Arun District Council
Arun Civic Centre
Maltravers Road
Littlehampton
West Sussex BN17 5LF
Planning & Building Control General Enquiries
Tel: (01903) 737756 Fax: (01903) 730442
Dx: 57406 Littlehampton
Minicom: 01903 732765
e-mail: planning@arun.gov.uk
website: www.arun.gov.uk/planning

Application No: EP/2/21/HH
Site Address: 27A Sea Lane East Preston BN16 1NH
Description of works: Erection of front extension to create first floor balcony, erection of rear balcony, demolition of existing conservatory with changes to external materials and wall finishes.

Thank you for your internet representation made on 3rd March 2021 which has been recorded as an objection with the comments as follows:

I am commenting on behalf of the East Preston and Kingston Preservation Society.
The Society objects to two features of this application: the addition of a rear balcony (shown on the plan but not mentioned in the Application), and the use of slate effect tiles on the roof.

Elevations (1:100)

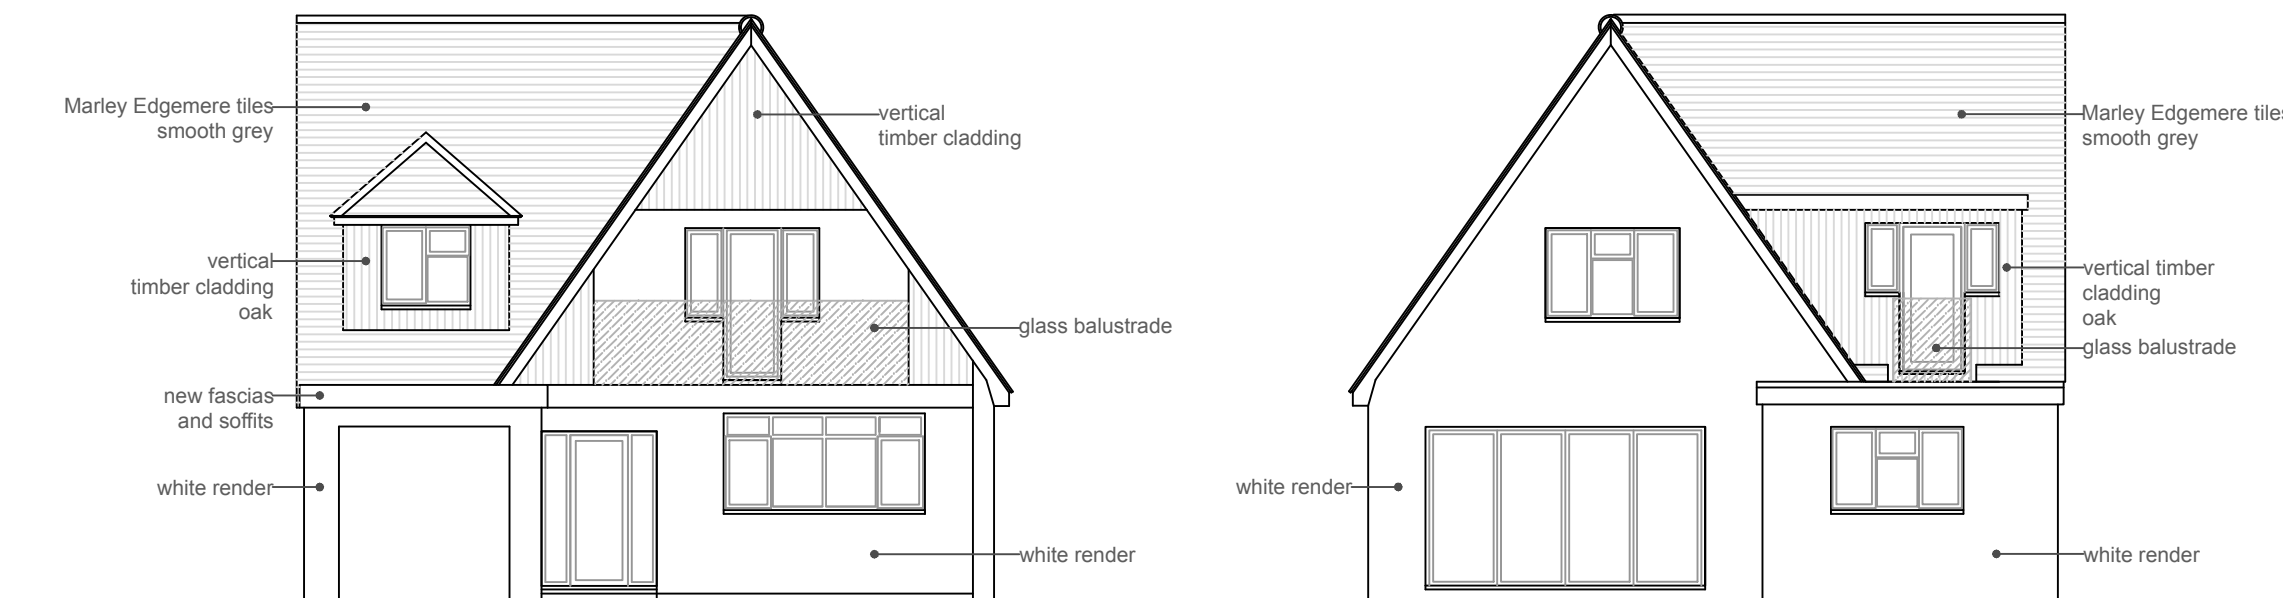
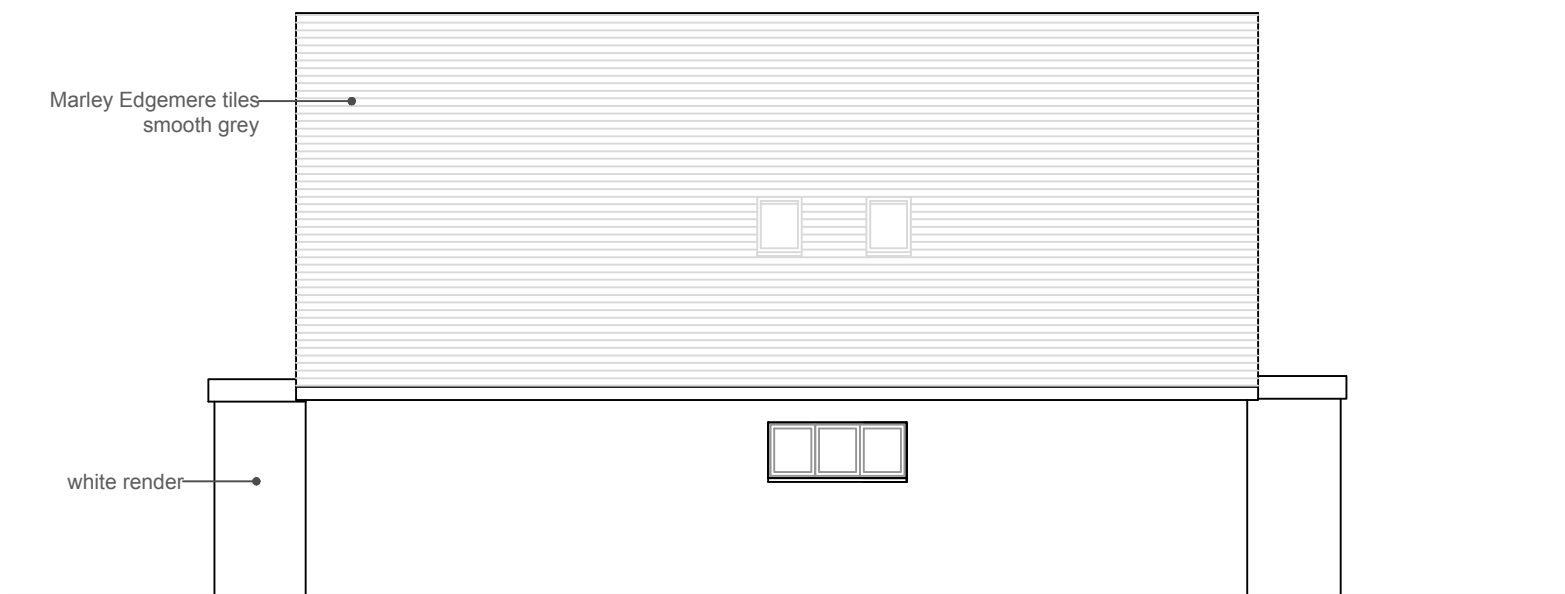
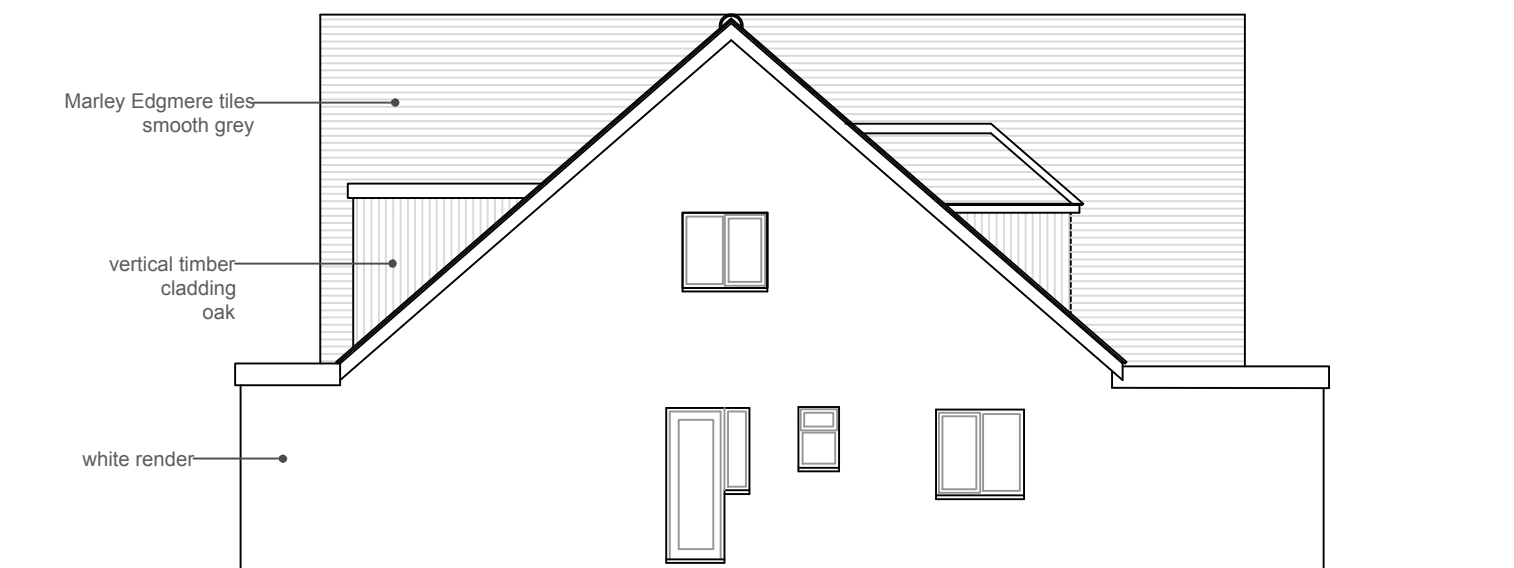
The rear balcony would overlook many houses and gardens, as the number of letters objecting to this feature testifies. Its construction would contravene policy D DM4 c. of the Arun Local Plan.
Slate effect tiles are not used on any house in Sea Lane. Their use on this house would therefore contravene policy D DM1 of the Arun Local Plan, and policy 1 of the East Preston Neighbourhood Plan, which states "Materials in new or altered buildings should harmonise in both colour and texture with the materials used in adjoining buildings".
